Recommendation Report for Planning Permission for Works or Extension to a Dwelling

REF NO: CM/32/14/HH

LOCATION: Redcot
Climping Street
Cllimping

PROPOSAL: Rear extension & loft conversion (resubmission of CM/7/14/HH)

Scale	1:100	Drawn By	ACB
Date	13/08/2014	Checked	CB
Drawing Number		1028 - 07

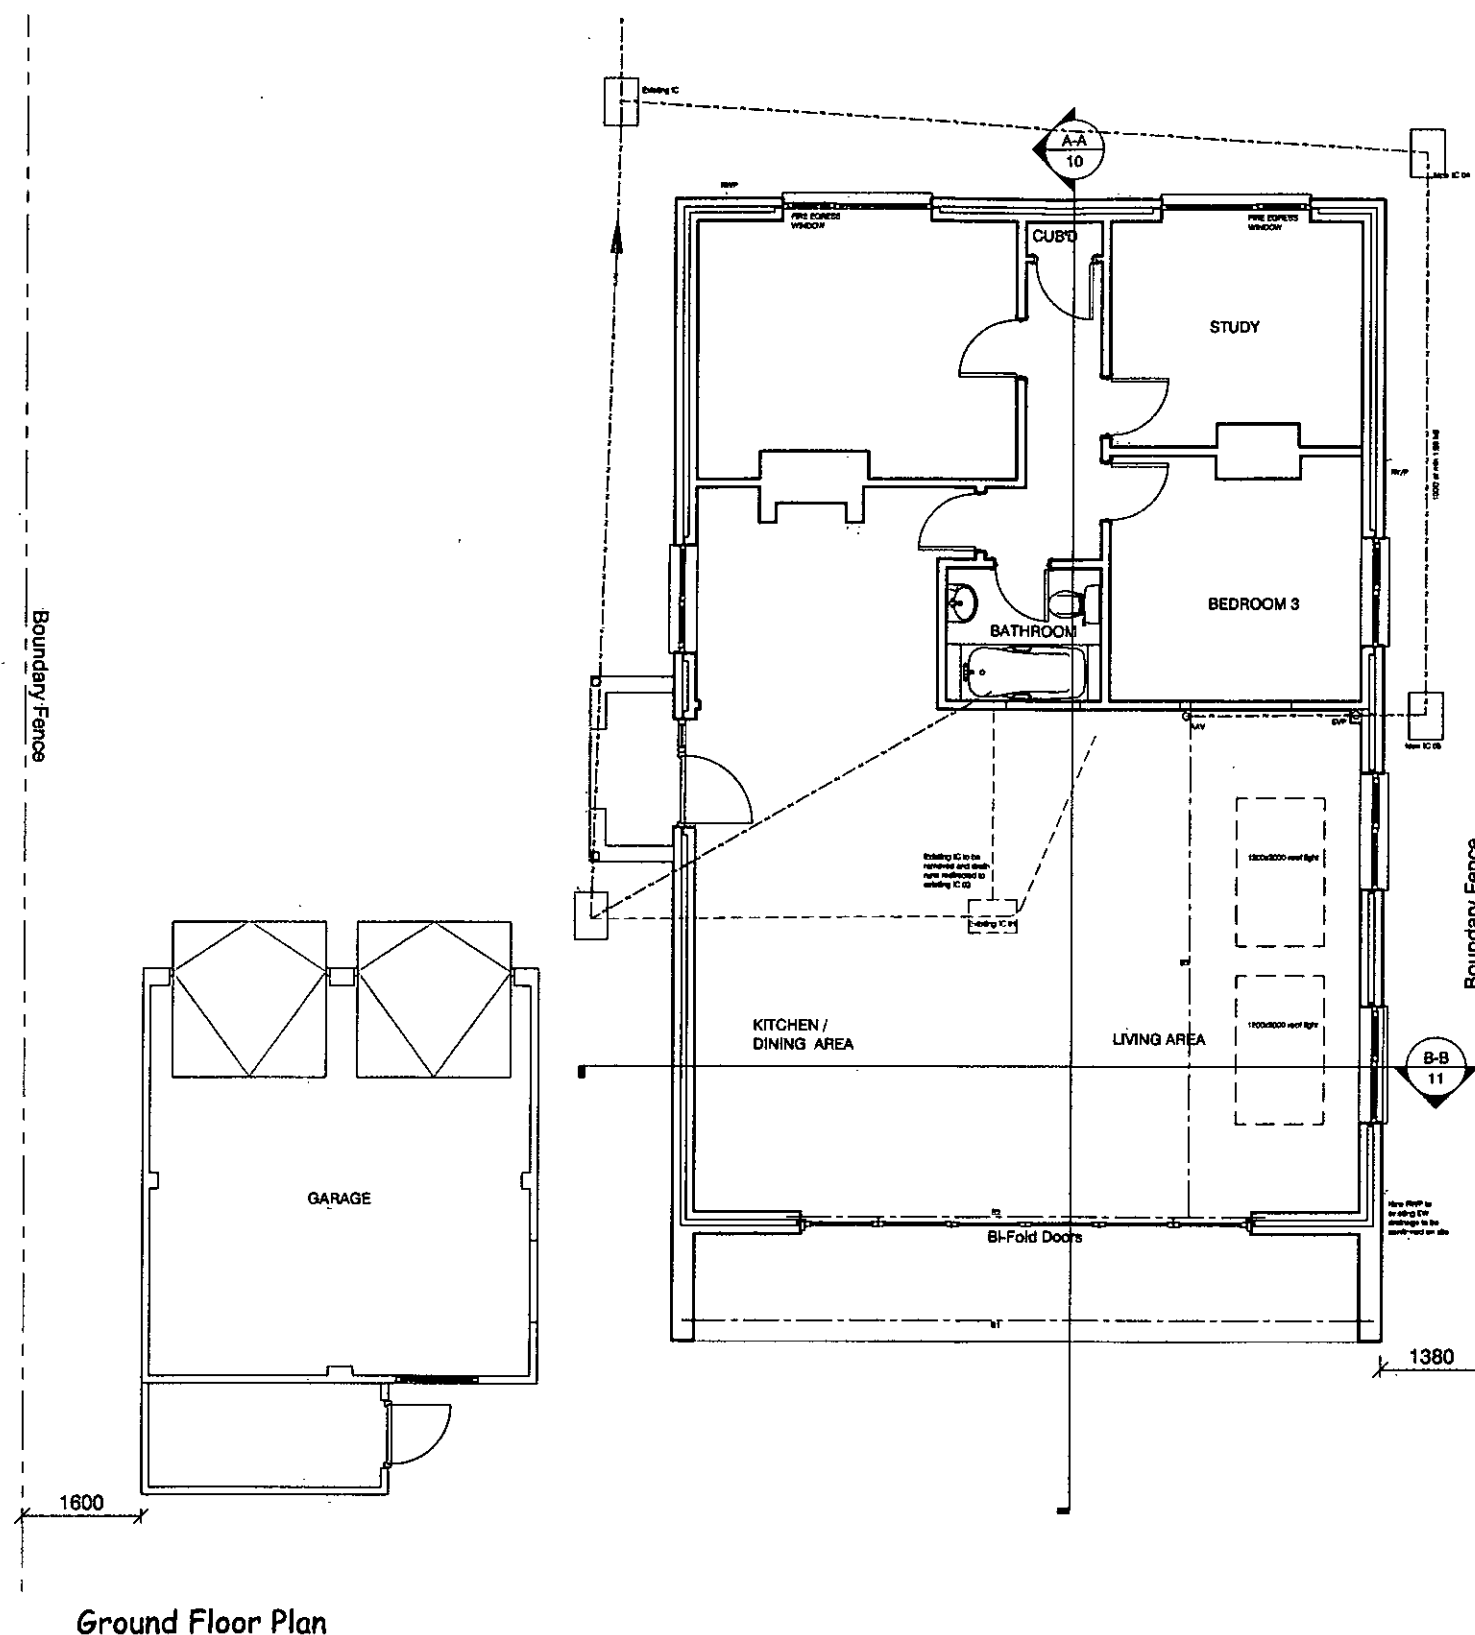
This application seeks planning permission for a single storey rear extension on a detached bungalow. This application forms a resubmission of previously refused planning application CM/7/14/HH and principally differs by now severing the link with the detached garage and no longer incorporating a side (east) dormer.

CM/7/14/HH by now extending back from the rear wall of the property rather than incorporating the garage as well. The proposed rear extension measures at its maximum 8.5m in length and at its northern extent at approximately 6.5m in length. It should be borne in mind that under Permitted Development, a rear extension can be built up to 4m in length and under Extended Permitted Development rights with neighbour notification up to 8m in length without the need for a planning application.

ELEVATIONS AS PROPOSED			
Scale	1:100	Drawn By	ACB
Date	13/08/2014	Checked	CB
Drawing Number	1028 - 09

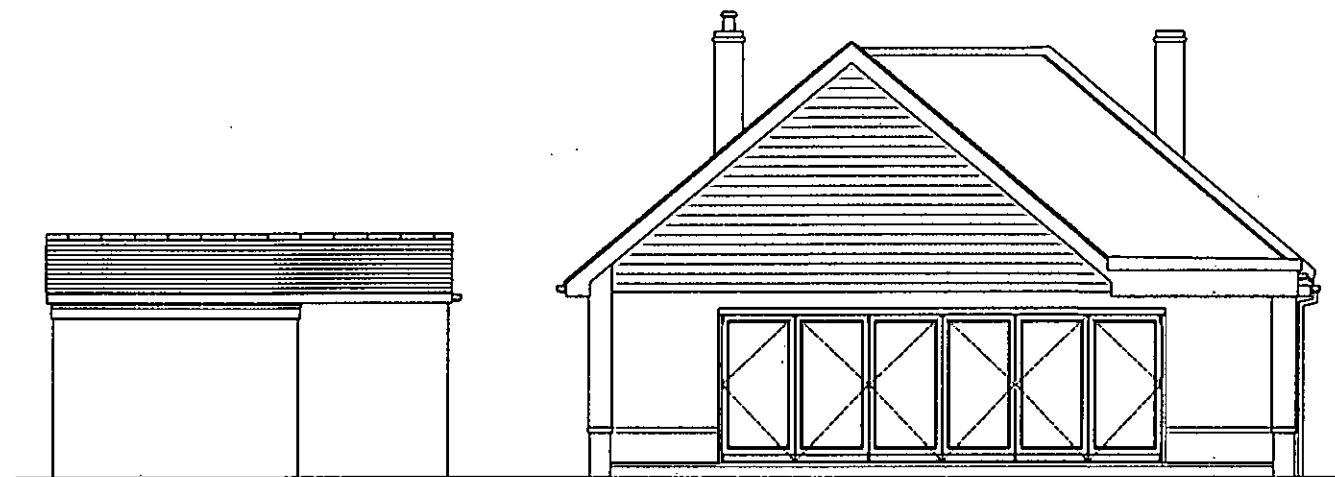
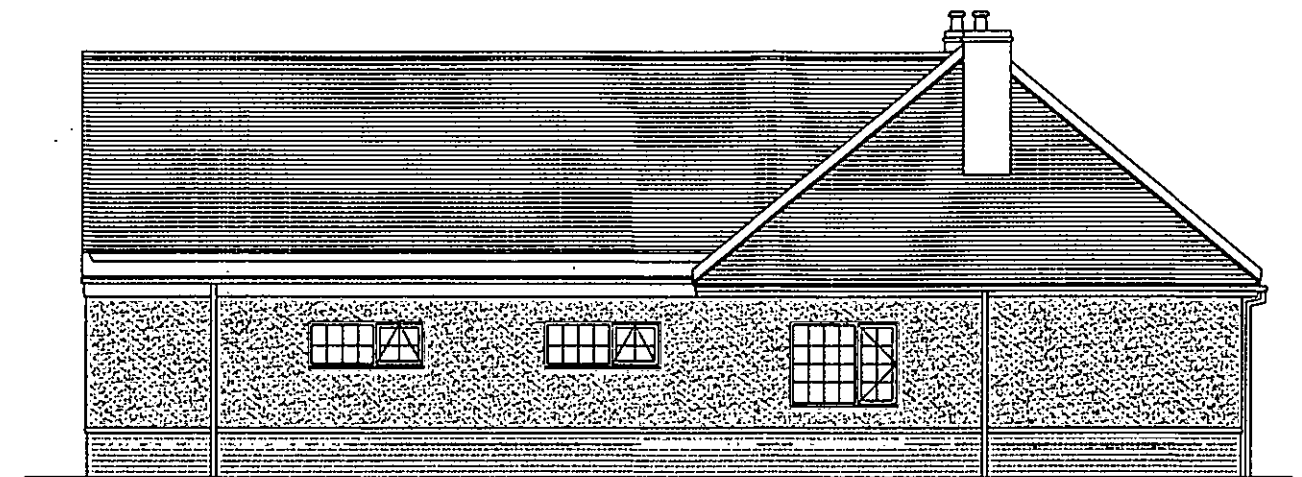
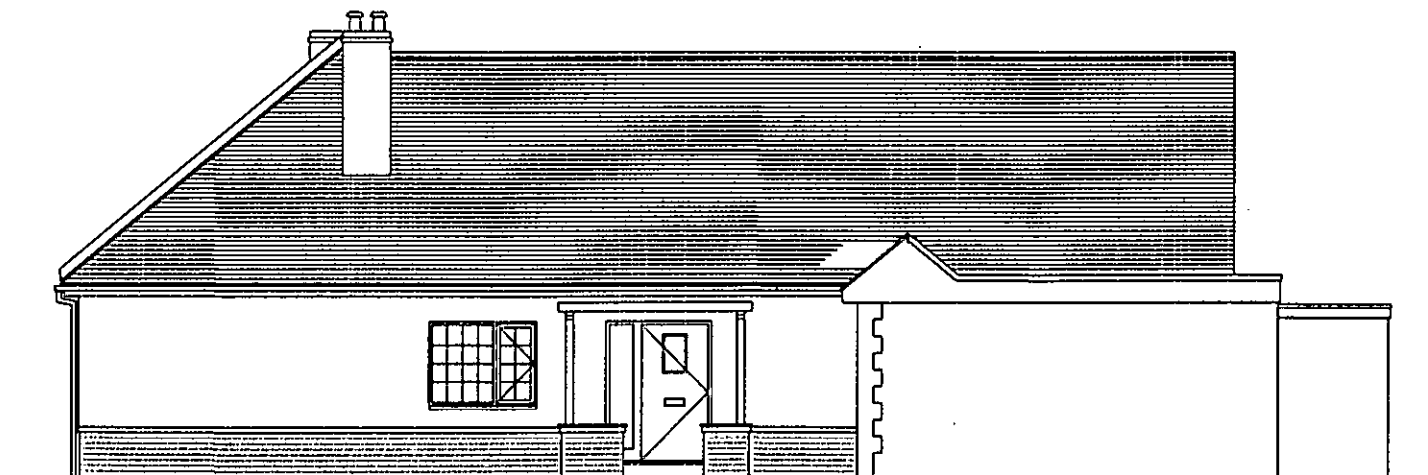
The rear extension forms a significant design improvement on previous planning application

In its footprint and dimensions, it is accepted that the extension is not visually subservient to the host dwelling which is a compact form of a dwelling. However, the conflict with policy DEV19(ii) is materially outweighed by the fact that the extension maintains existing eaves and ridge heights of the property, will be visually integrated by way of matching materials and is situated to the rear where it will not be readily seen in the street scene.

The proposed extension at single storey in height and with an absence of any windows in the roof is also set acceptably away from any neighbouring property so as to not cause any harmful overbearing, overshadowing, overlooking or loss of privacy.
